DEVIATION REQUEST AND DECISION FORM

Project Name : Falcon Meadows @ Bent Grass Filing No. 4 Schedule No.(s) : 5301201061, 5301201062, 5301201063, 5301301054 Legal Description : Falcon Meadows @ Bent Grass Filing No. 4

**DEVIATION REQUEST** (Attach diagrams, figures, and other documentation to clarify request)

A deviation from the standards of or in Section **2.3.4 – 2.3.4** of the Engineering Criteria Manual (ECM) is requested.

LEMON GRASS DR. (STREET L) STA: 6+00 - 7+94.08
 SCALE: H: 1"=30' V: 1"=3'

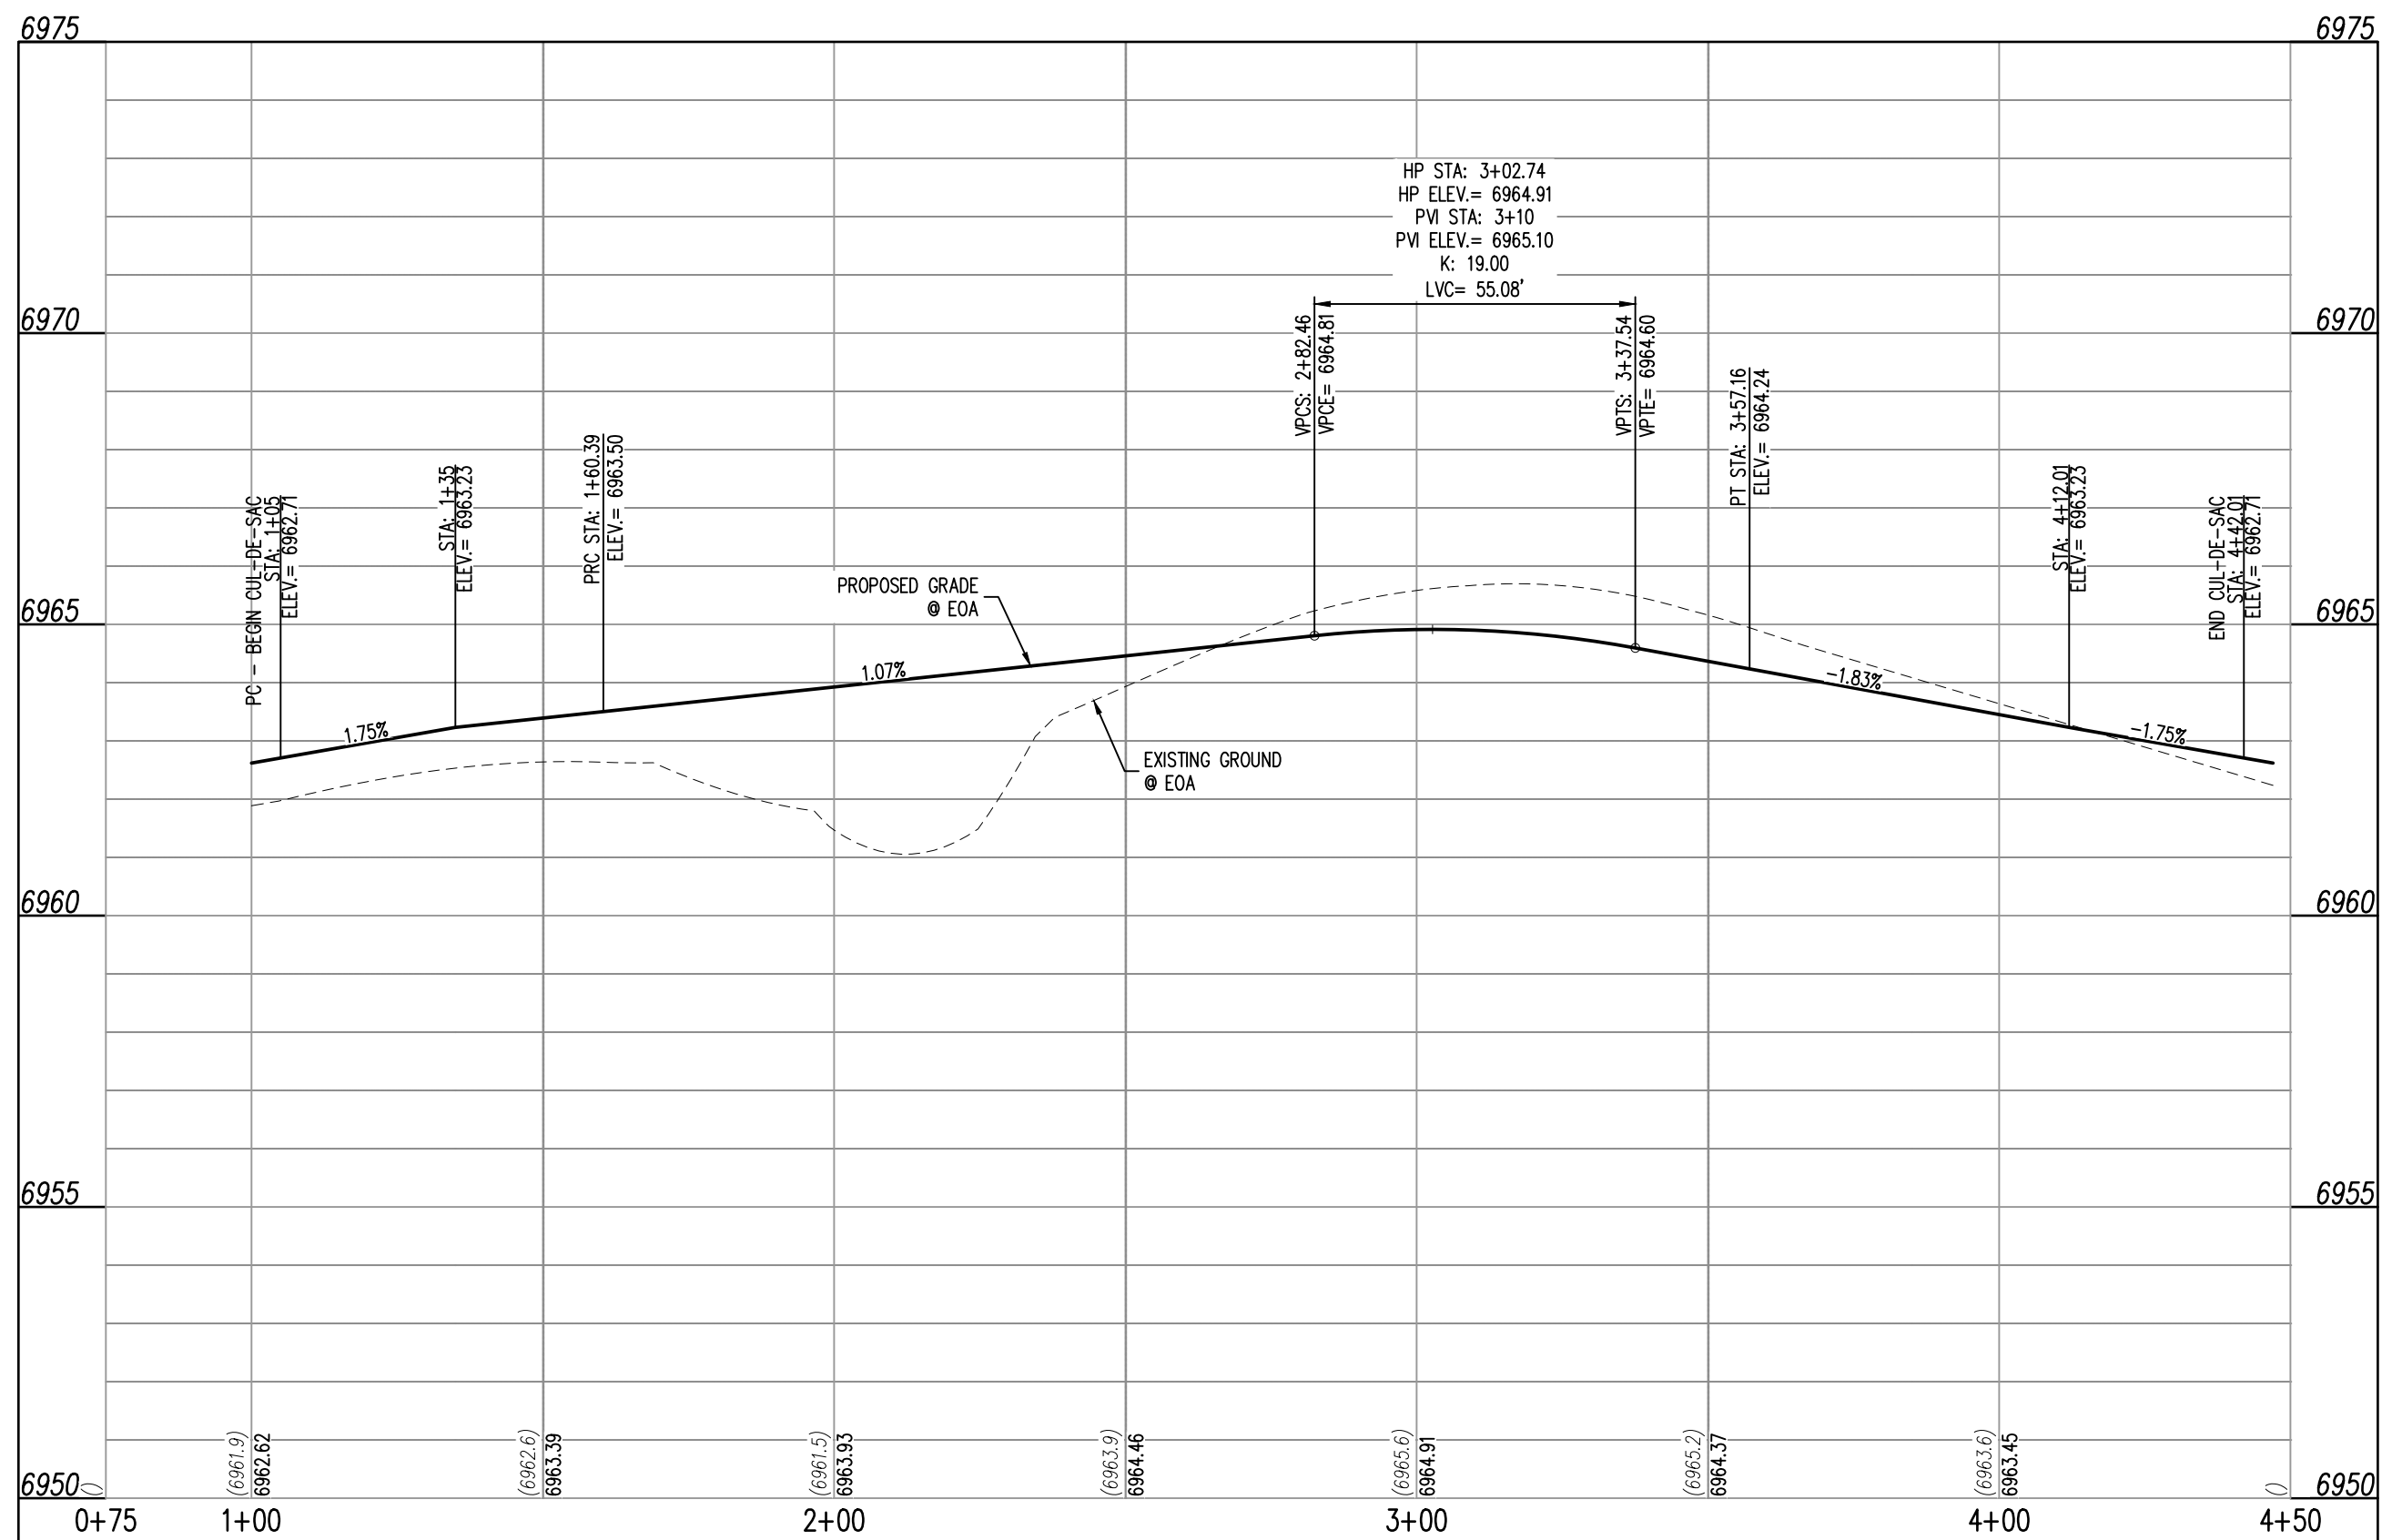
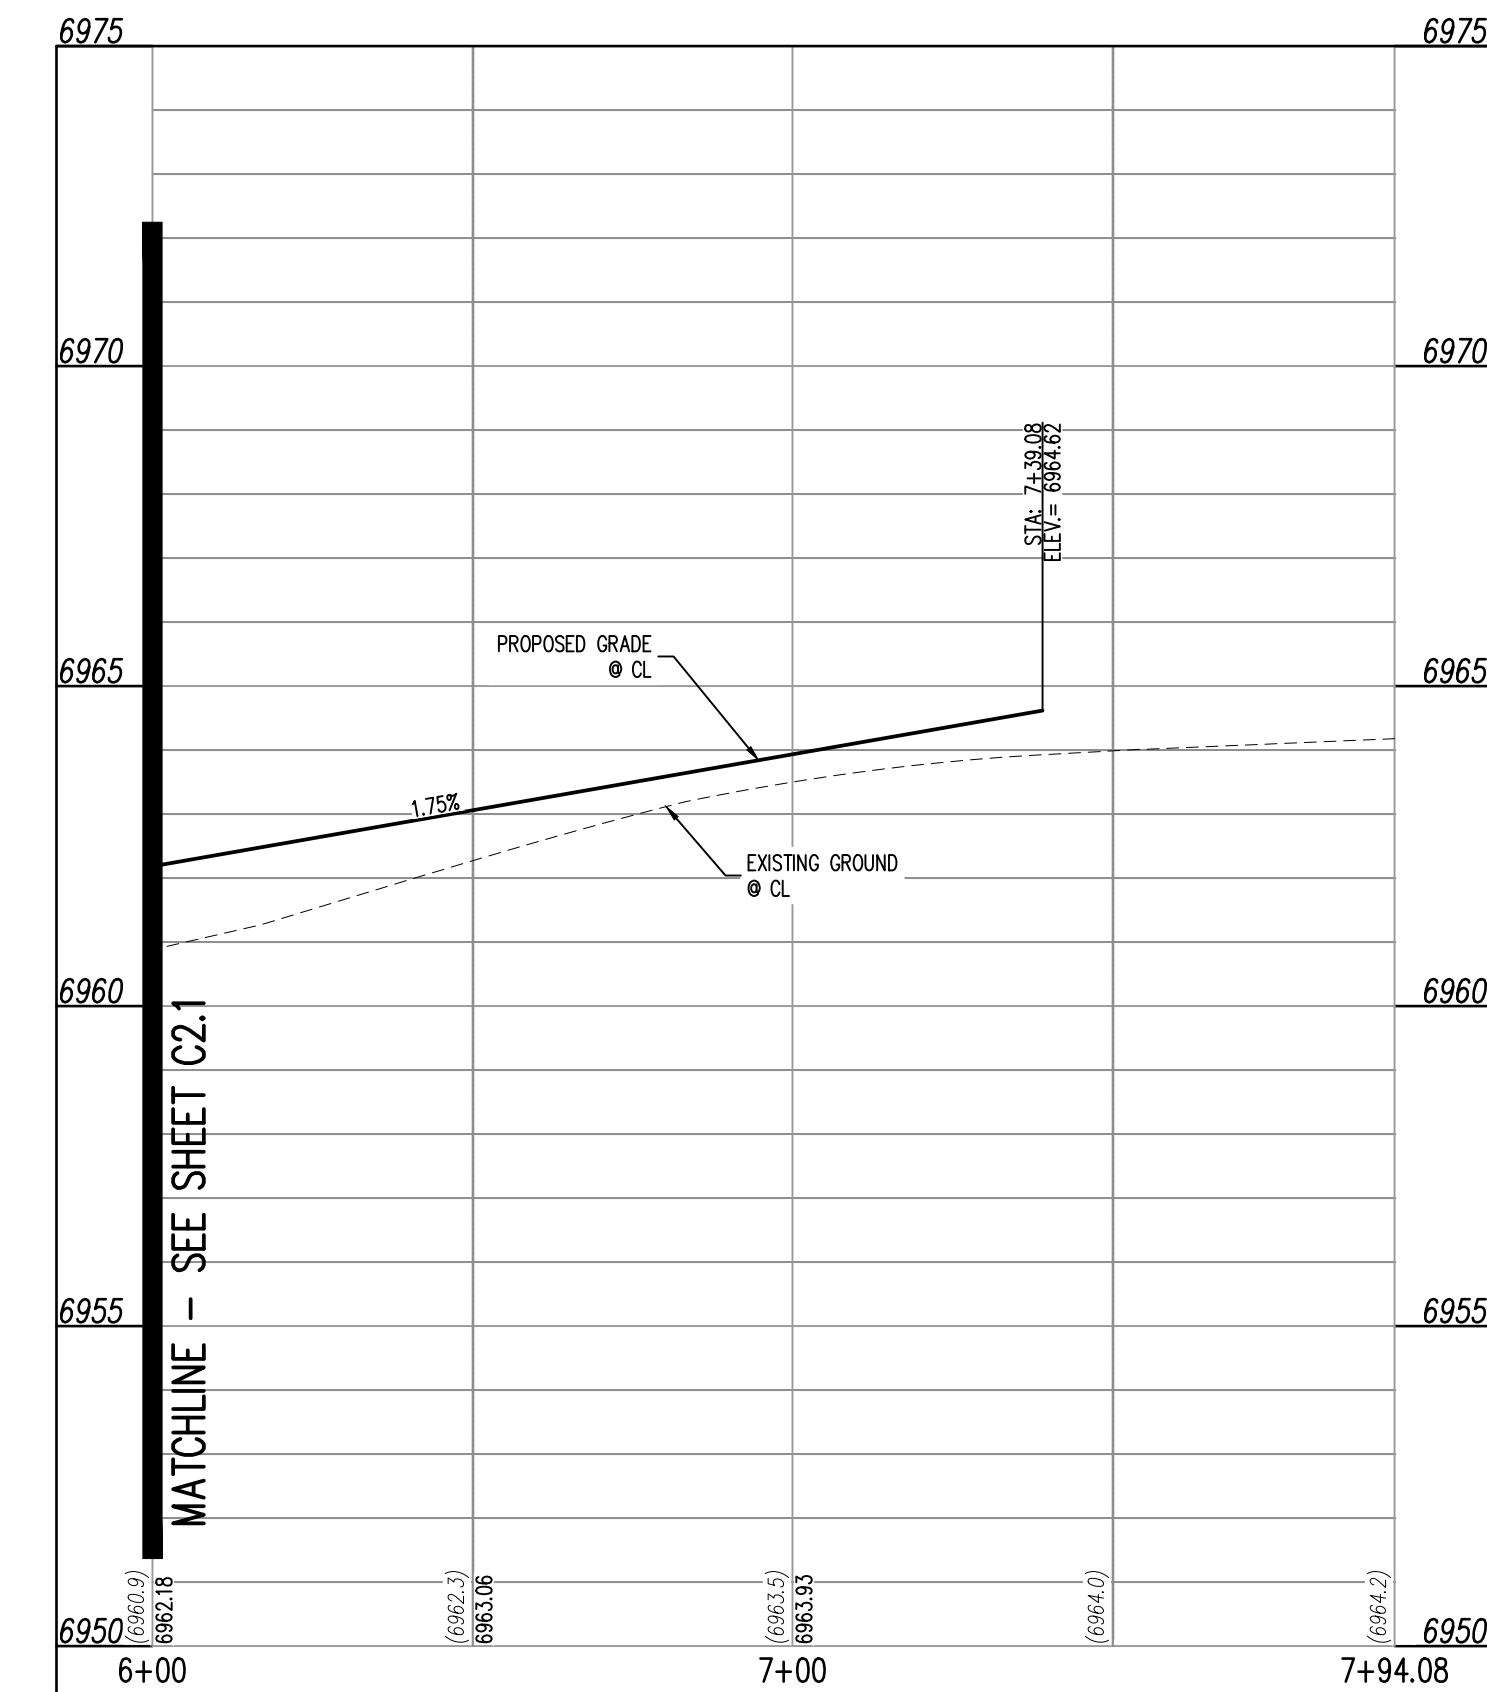
We are requesting a deviation because our minimum K values are not being met on our Lemon Grass Road Improvement Plans in our Construction Drawings and we are not able to adjust the design in this area sufficiently to meet the K value requirements.

We are proposing to maintain our current K values in our current plan. The K value for our non-compliant sag curve is 11.30 whereas the ECM standard is requiring a K value of 26. The K value for our non-compliant crest curve is 6.67 whereas the ECM standard is requiring a K value of 12.

Explain why Willmore, Silky Thread, and the north end of Lemon Grass Road cannot be revised to fix this situation.

What design speed would work with the vertical curves proposed?  
Address AASHTO requirements.

Due to the existing roads that Lemon Grass Rd. is tying into (Bent Grass Meadows Drive and Willmore Drive), the K values presented are the maximum K values we can produce given the horizontal and vertical constraints, while maintaining compliance to ADA standards.
